**KIRKLEES METROPOLITAN COUNCIL
INVESTMENT & REGENERATION SERVICE**

DELEGATED DECISION TO DETERMINE PLANNING APPLICATIONS

Reference No:	2026/62/91532/W
Site Address:	4-6, Cambridge Road, Huddersfield, HD1 5BU
Description:	Change of Use from Bridge Club to Guest House and associated alterations
Recommending Officer:	Elenya Jackson

DECISION - REFUSE

#### Proposed Site

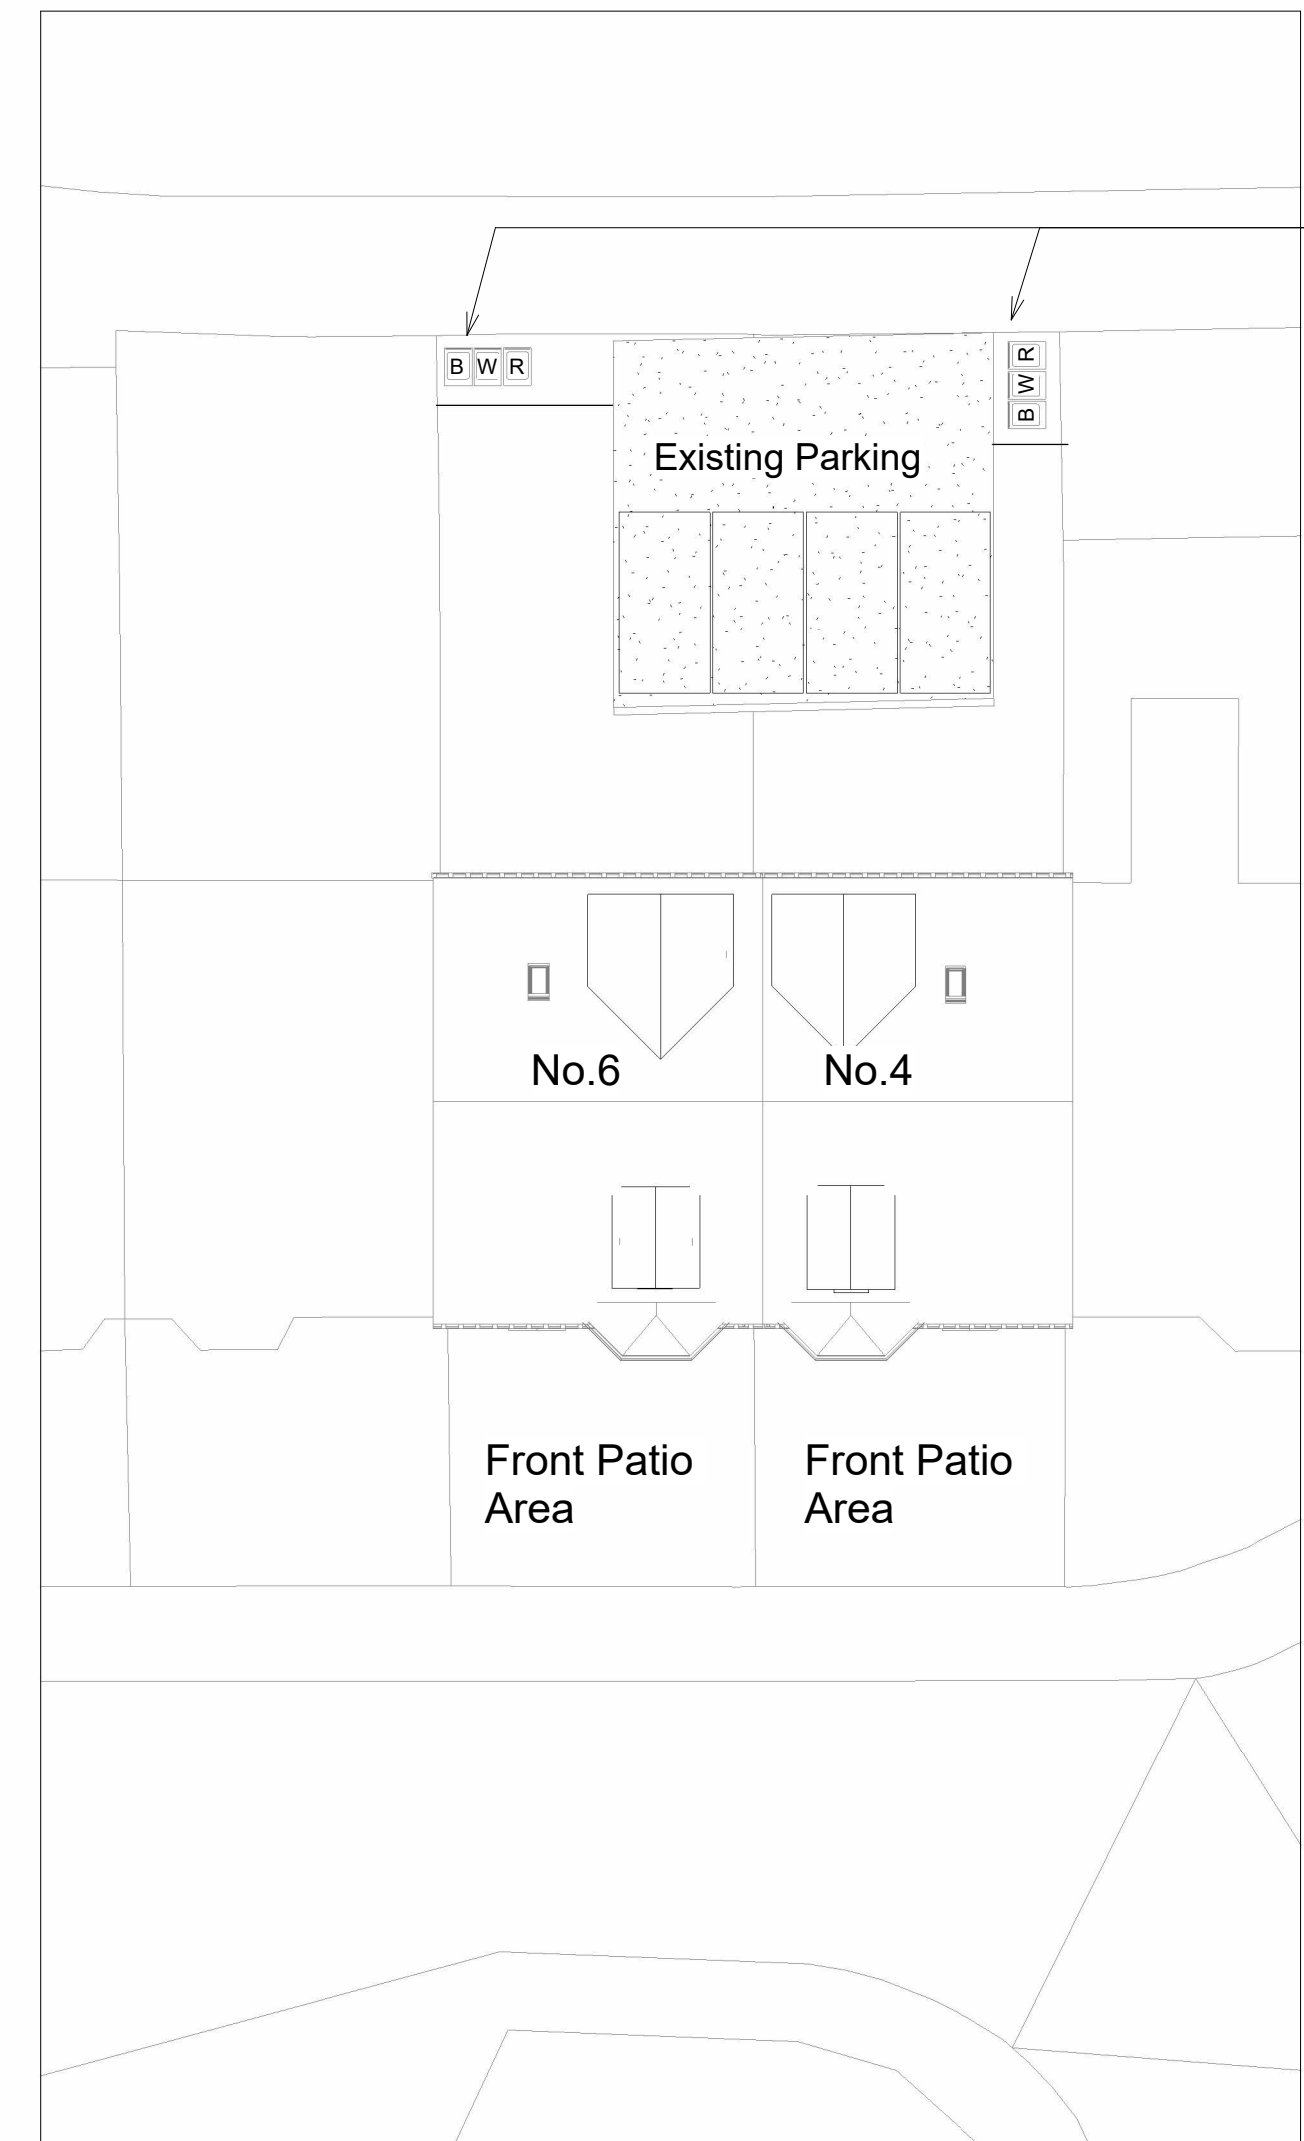
The relocation of the bin storage would be preferential to the rear of the site as it would prevent the removal of the wall to the principal elevation of the building which is an attractive characteristic of the site.

There are four parking spaces provided on site and there are parking restrictions in the area in the form of permit holders only parking. Users of the guest house would be unable to obtain a parking permit and an additional 22 permits would not be provided to support a commercial enterprise in this setting.

It is considered that the use as a HMO would not provide an acceptable justification for the intensification of the use of the site as a 22-bed guest house. Individuals who occupy a HMO would be residents of the area, whereas a guest house would be short stay accommodation for visitors of the area and would be likely to rely on the use of a vehicle to access the site for short durations of time. In addition, the site would create 8 additional bed spaces on site which would represent a further intensification.

As such, by reason of the intensification of the use of the site, the scheme would cause harm in terms of highway safety due and as such would fail to comply with LP21 and Policy LP22 of the Kirklees Local Plan along with Key Design Principles 15 & 16 of the House Extensions & Alterations SPD.

1. The proposed change of use of 4-6, Cambridge Road, Huddersfield to a 22-bedroom guest house would, by reason of the intensity of the proposed use, the intensification of the use of site, inadequate level of parking provision and inability to provide additional parking, result in an unacceptable impact on highway safety and the surrounding highway network. The proposal is therefore contrary to Policies LP21 and LP22 of the Kirklees Local Plan and guidance contained within chapters 9 and 12 of the National Planning Policy Framework.
